Subject: Scoped Urban Design Brief – Site Plan Control (Revision) Application  
379 Cooper Street, Ottawa ON

Table 1. Response to staff Pre-Application Consultation comments

DRAWING:
FLOOR PLANS

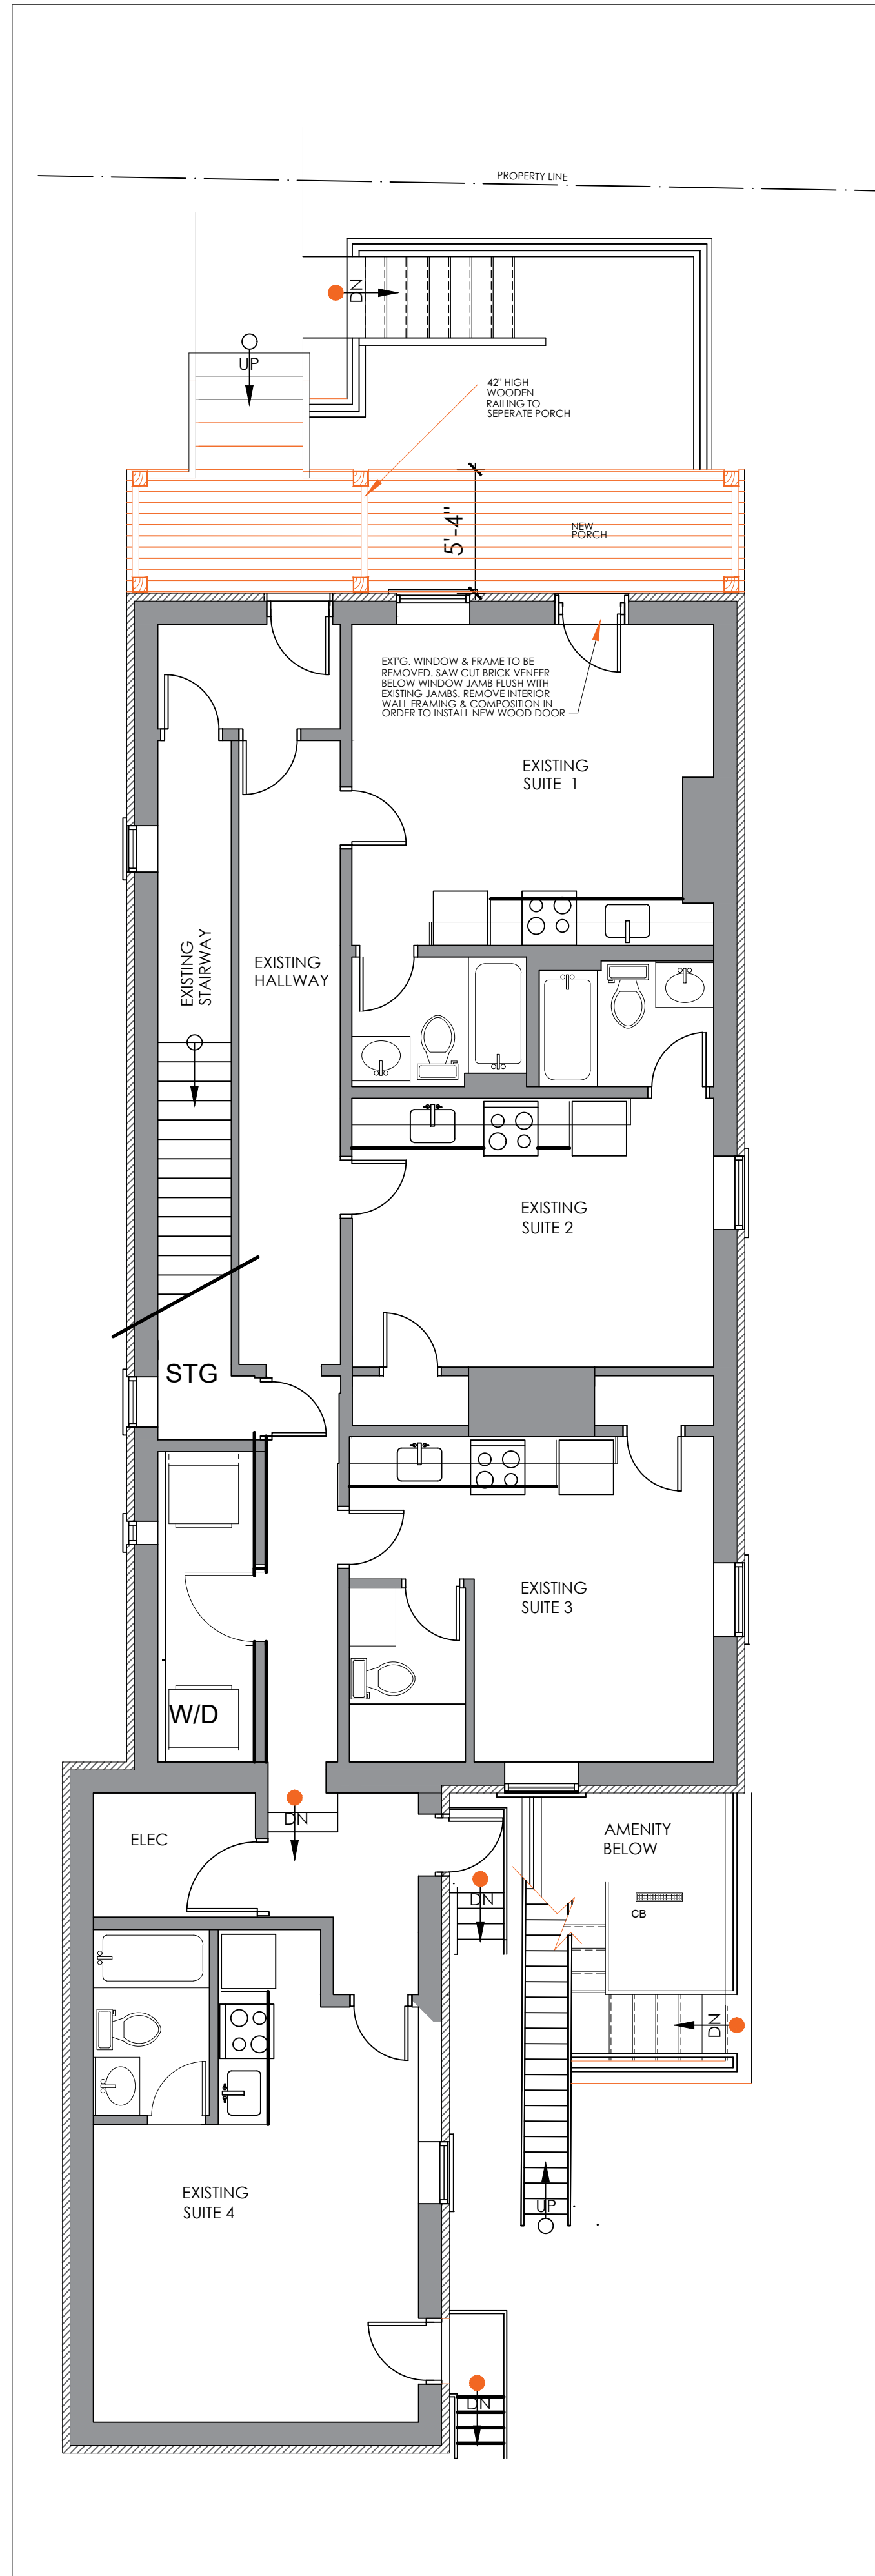
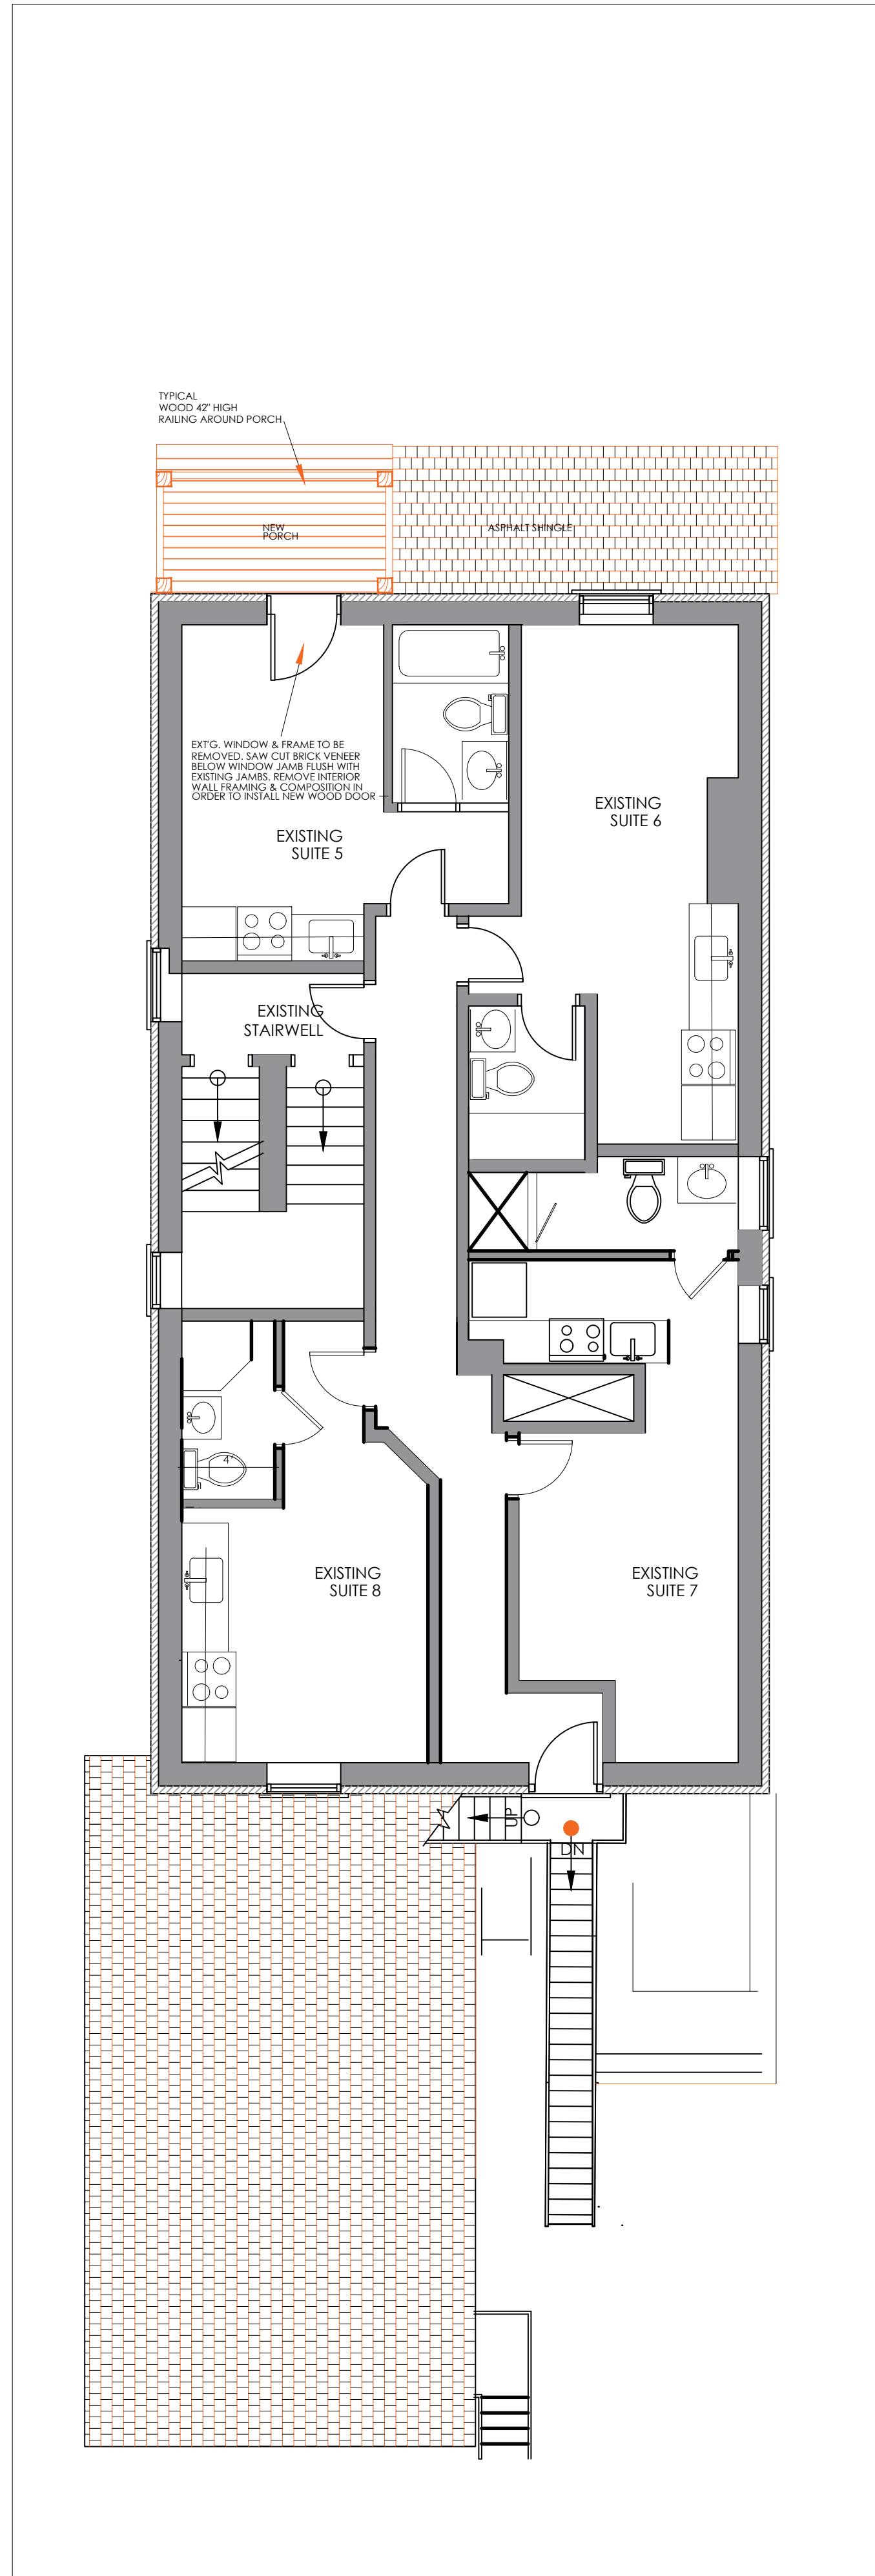
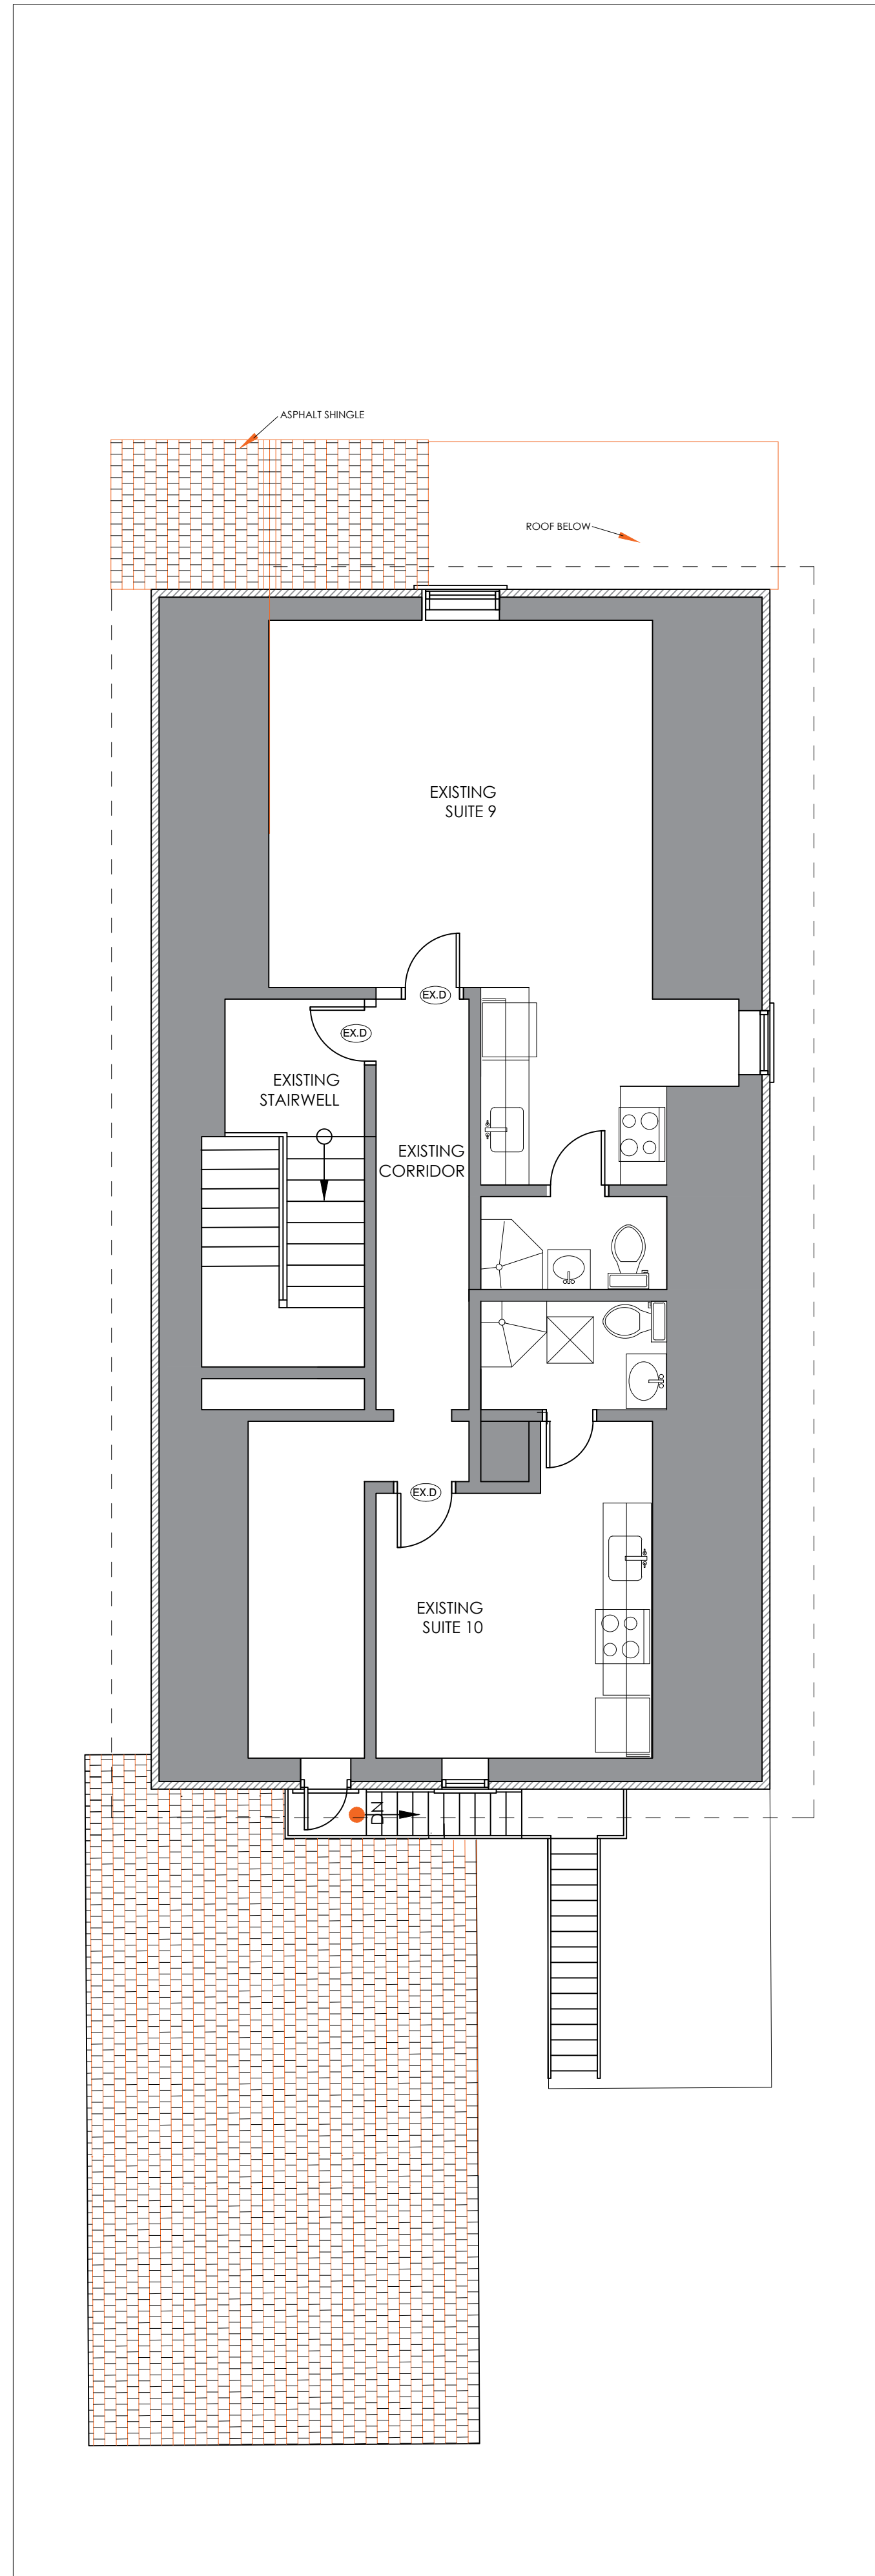
| COMMENT   | RESPONSE  |
|---|---|
| Accessibility: We recommend checking this requirement when having 13 residential units. Wheelchair access may need to be provided.  | This is an existing 10-unit building and the proposed development is for three units in the existing basement. No alterations to the building envelope. The building will comply with OBC requirements. |
| Ramp location: If wheelchair access is required, we recommend locating in a place other than the front yard to minimize the reduction in front yard landscaping. We can review the site layout further once additional information is available.  | Refer to response #2 above. If required, a ramp can be addressed at time of building code review.   |
| Bike parking location: We recommend bike parking be located in a secure and weather protected location and not in the front yard.   | Bike parking is secure, located in the rear yard, and zoning compliant.   |
